Re: Objection to MP08_0244 MOD 1 Modification Request for Mixed Used Development at 23-37 Lindfield Avenue and 11 Havilah Lane, Lindfield

Drawing Title
BASEMENT 1 PLAN

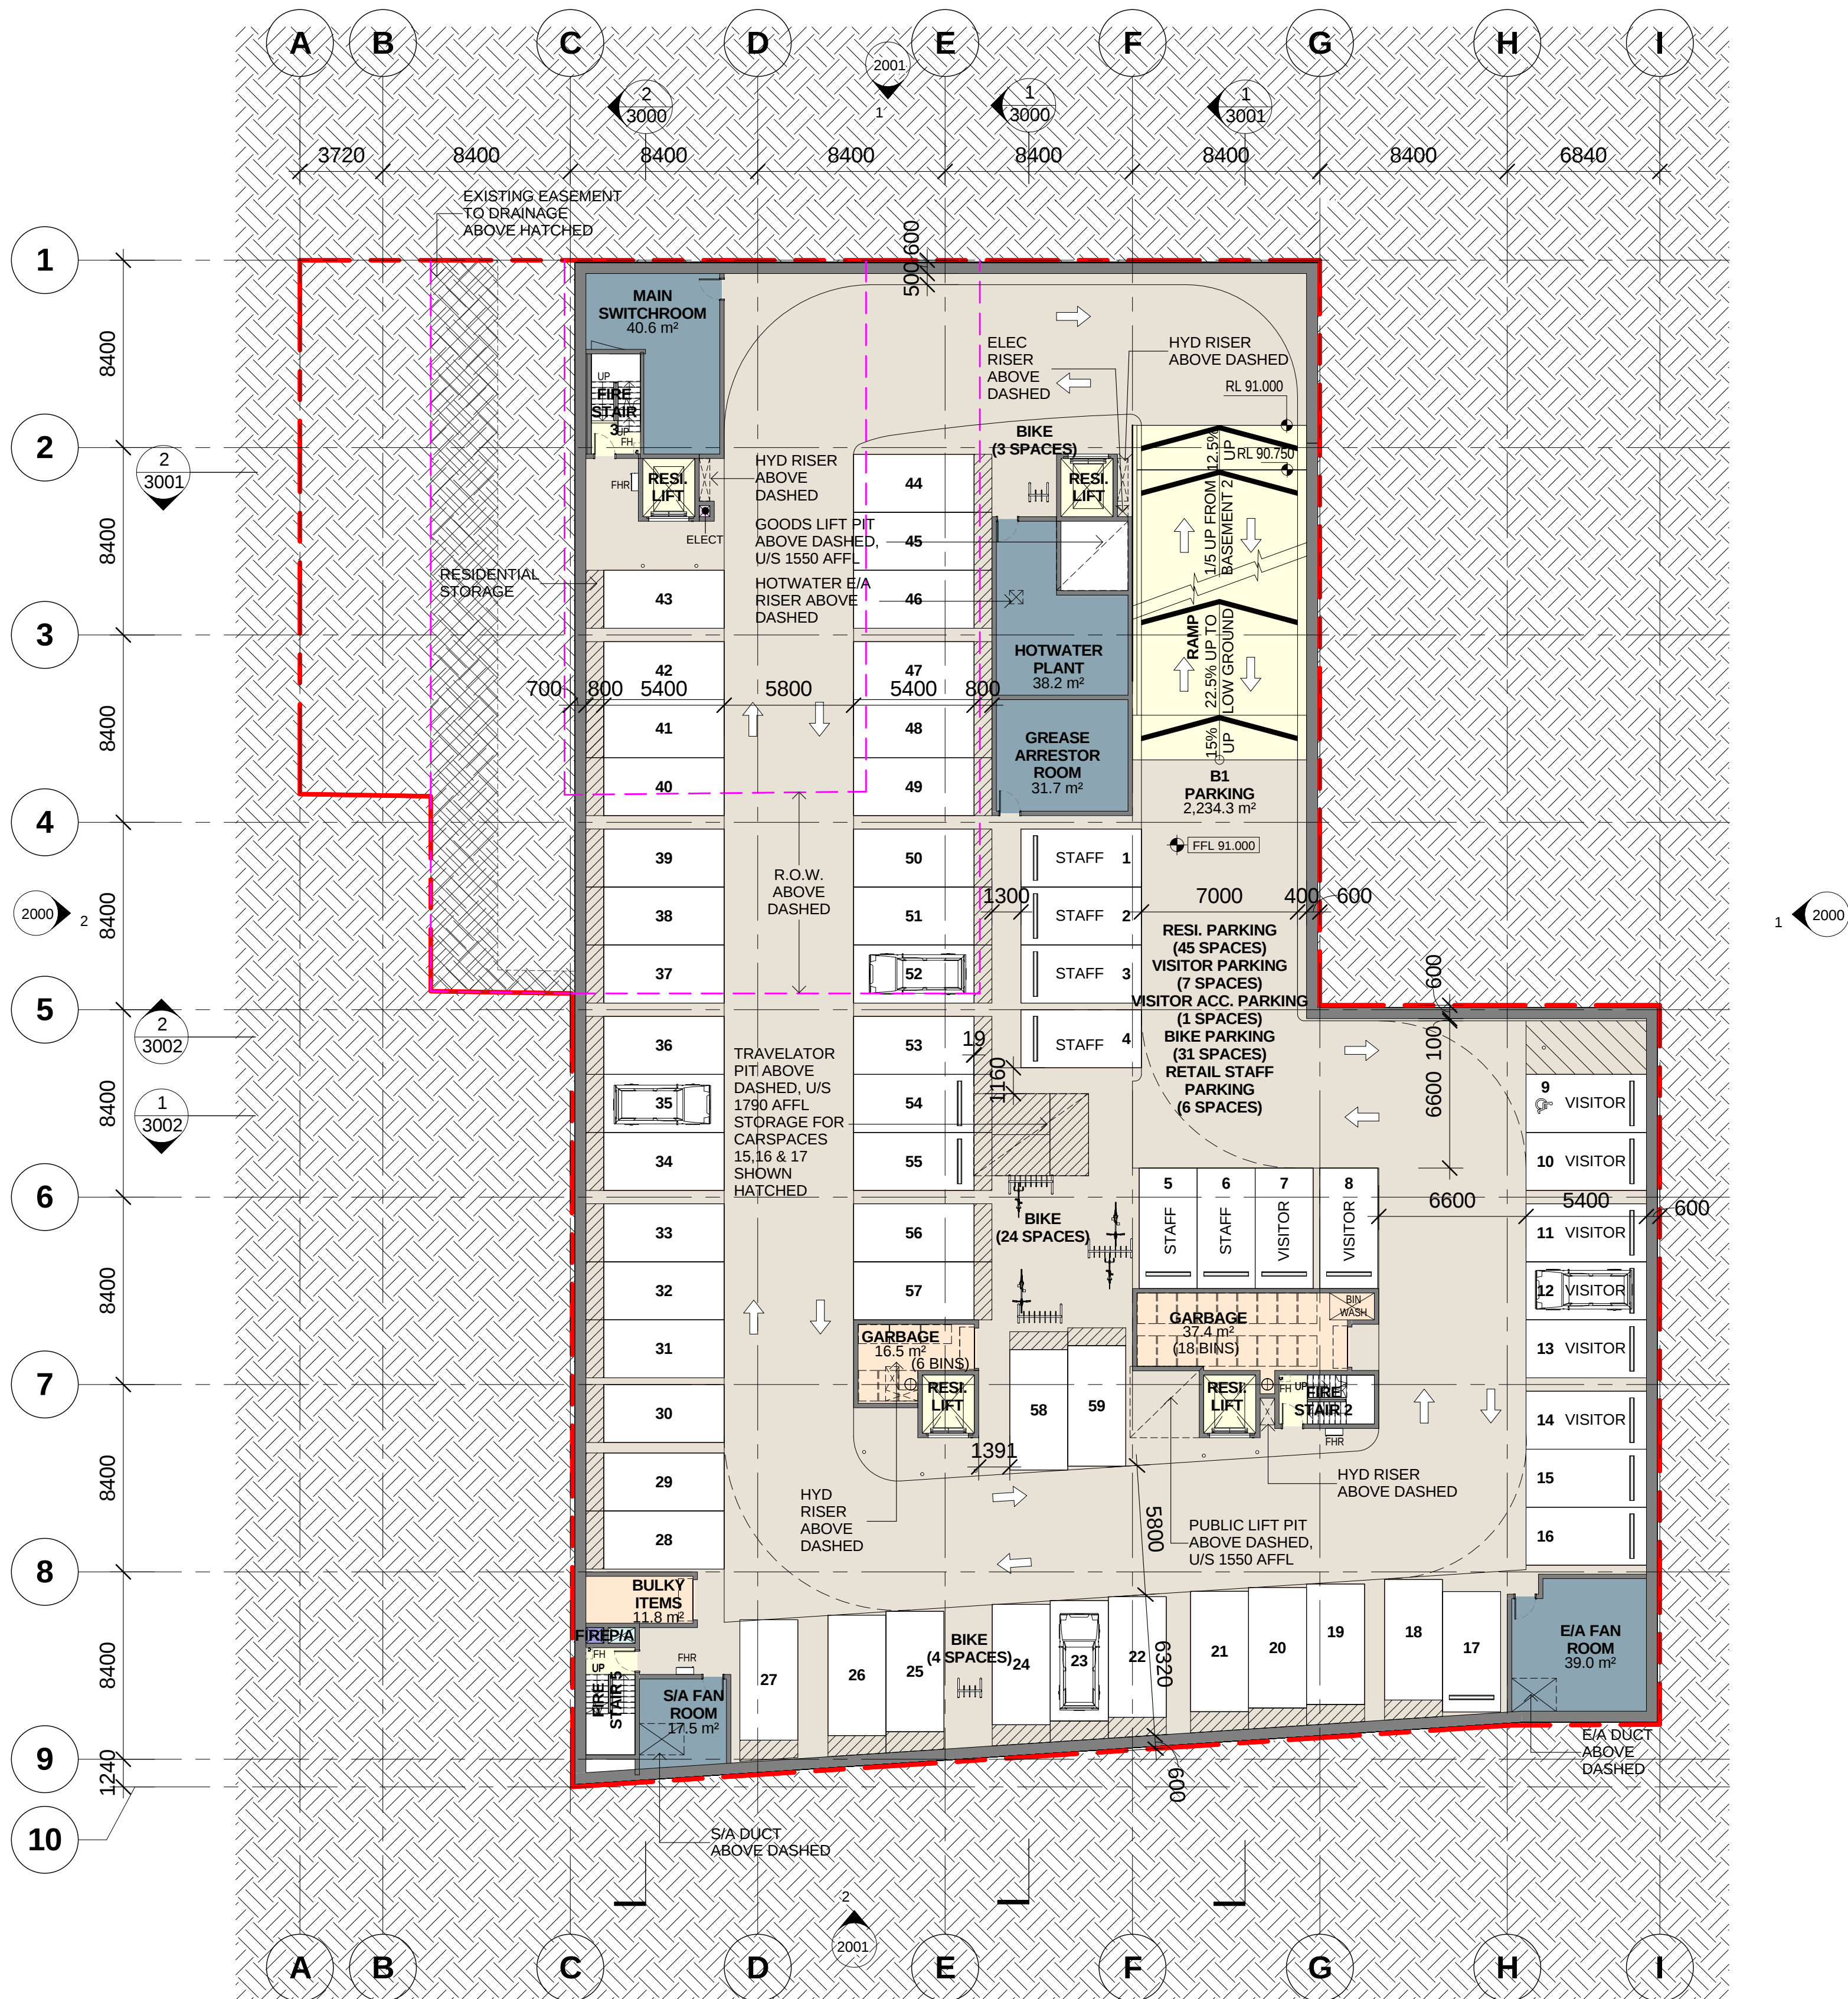
- Car spaces were identified as inadequate for the retail component and this has not been addressed relative to the remaining retail space proposed. The 25 car spaces counted as part of council's car park are also now highly uncertain due to the proposed rezoning and potential redevelopment.
